Rezoning Transportation Analysis
Petition Number: Insert Zoning Petition #2021-025
General Location Identifier: Tax ID 16511318

From: Robyn Byers, Ph.D.
Robyn.Byers@ci.charlotte.nc.us
704-336-7404

Reviewer: Lynda Jensen
Lynda.Jensen@charlottenc.gov
704-432-0672

Revision Log:

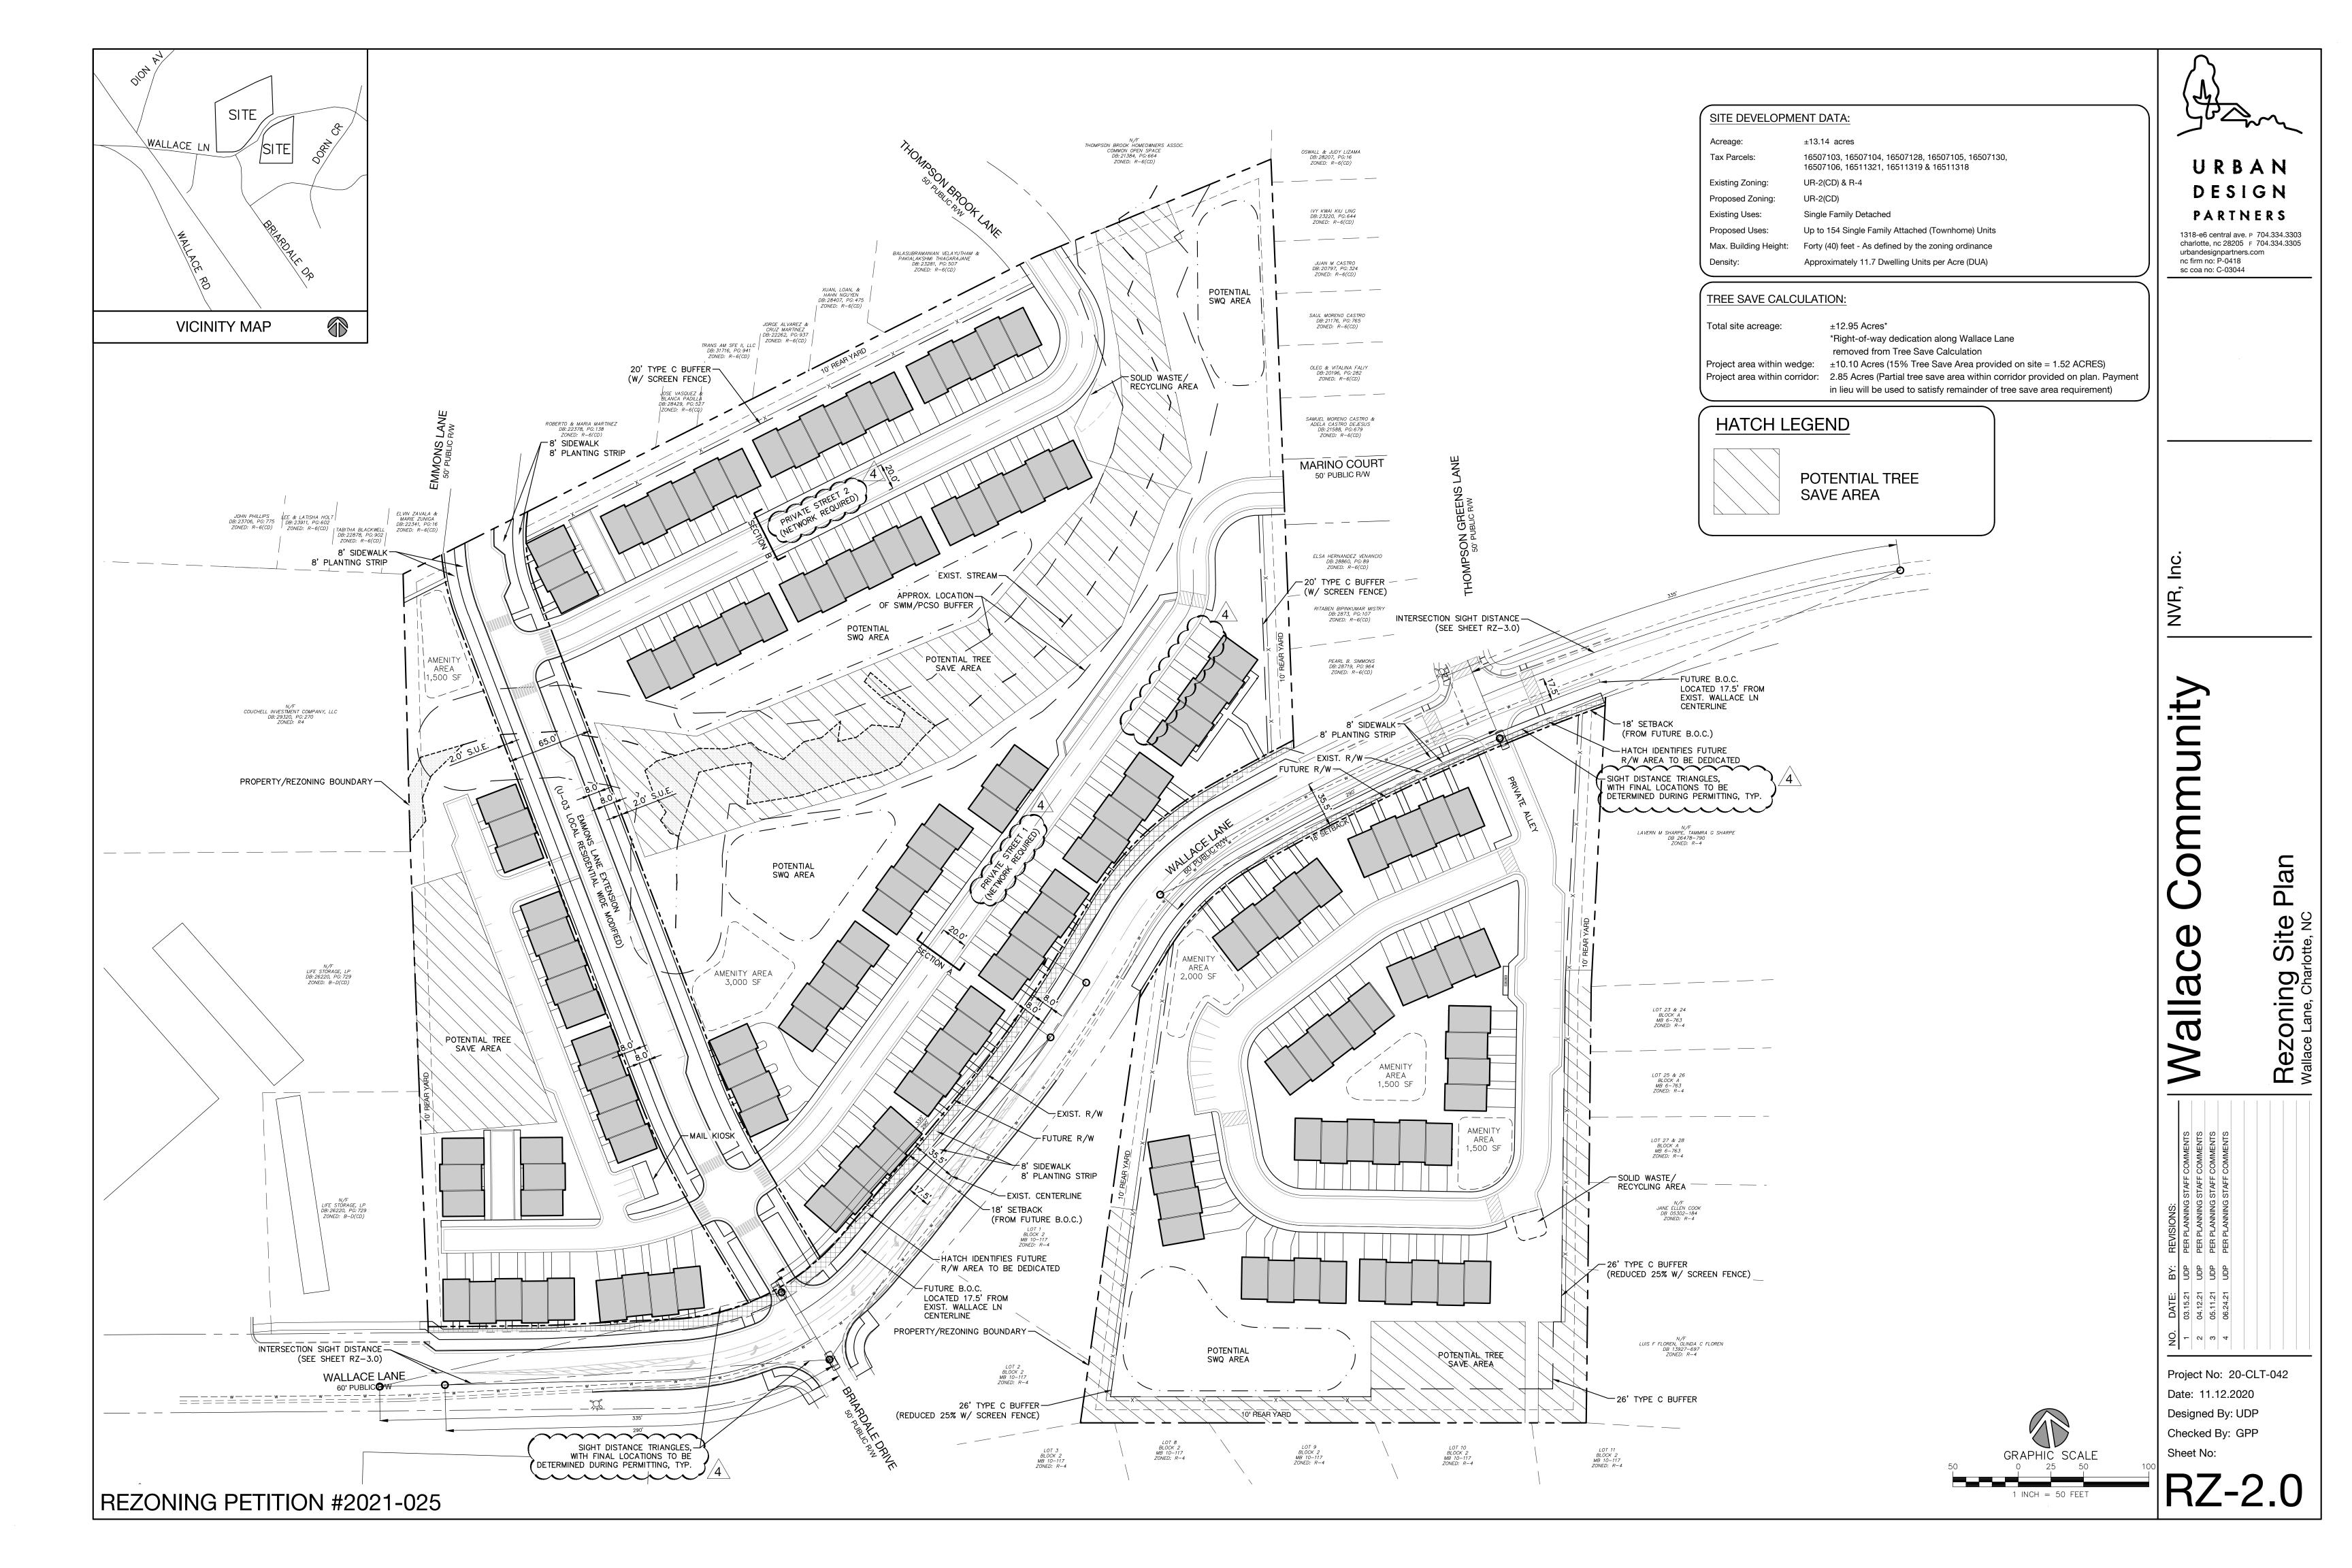
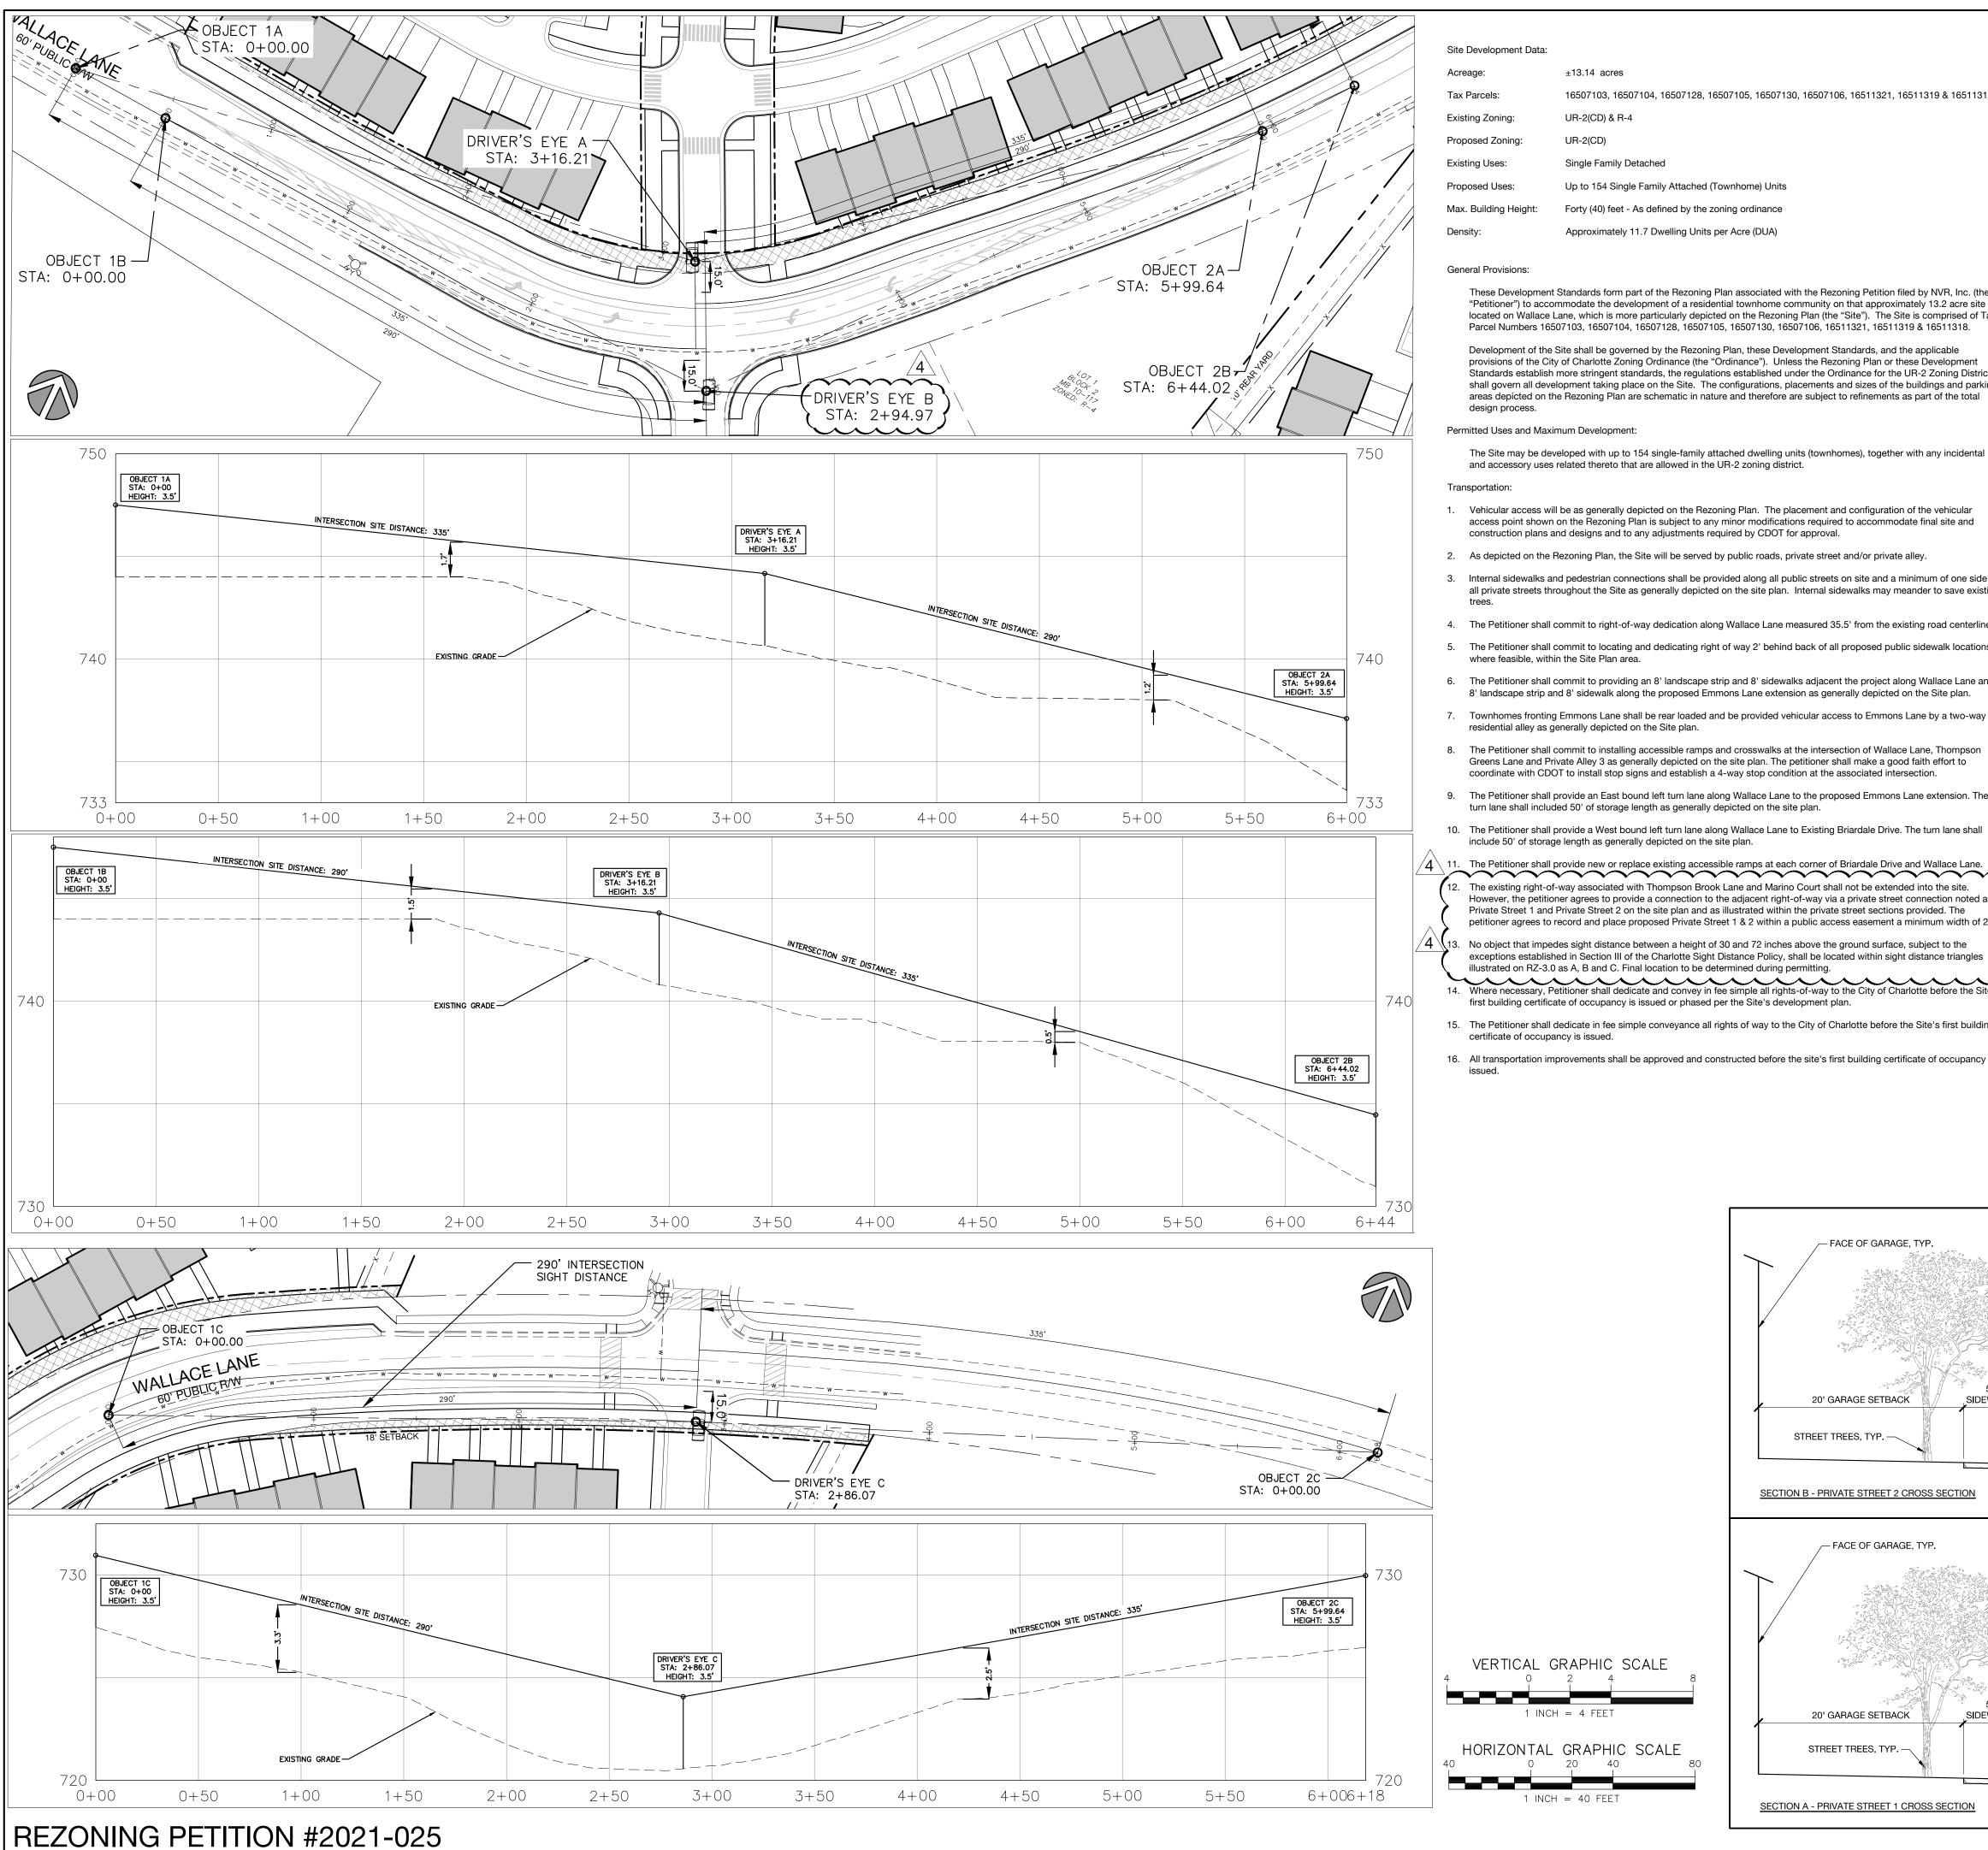
4. **OUTSTANDING (03/18/2021):** Revise site plan and conditional note(s) to commit to construct an 8-foot planting strip, and 8-foot sidewalk on Wallace Lane and Emmon Lane extension per Chapter 19 / Chapter 20. The site plan shall label and dimension both items from the back of curb and gutter and road centerline. CDOT request of rights-of-way set at 2' behind back of sidewalk where feasible.

- 7. ~~**New Comment (03/25/2021):** Revise site plan and conditional note(s) to commit to constructing left turn lanes into the development per CDOT standards for developments that generate more than 500 trips a day.~~
~~**Update to Comment as a Result of the 04-12-2021 Site Plan:** Revise the site plan and conditional notes by committing to constructing a westbound left turn lane, on Wallace Lane, onto Briardale Drive. This will provide a more fluid full-movement intersection.~~

- 8. ~~**New Comment (03/25/2021):** Revise site plan to demonstrate adequate Intersection Sight Distance (ISD) at all proposed public street connections to existing Wallace Lane per CDOT Sight Distance Policy and to ensure safe ingress and egress into the development. ISD must be shown in both horizontal and vertical dimensions (plan/profile) along the sight line, not the roadway centerline.~~
~~**Update to Comment as a Result of the 04-12-2021 Site Plan:** Revise the ISD Profile for Emmons Lane Extension and Wallace Lane to depict Stopping Sight Distance Profiles in addition to Intersection Sight Distance Profiles. Additionally, revise the ISD Profile for Private Alley 3 and Wallace Lane to show the left turn sight line profile.~~
~~**Update to Comment as a Result of the 05-18-2021 Site Plan:** Realign the ROW along the sight line or provide an easement to protect the sight triangle by adding a note stating that "No object that impedes sight distance between a height of 30 and 72 inches above the ground surface, subject to the exceptions established in Section III of the Charlotte Sight Distance Policy, shall be located within any of these three sight triangles."~~
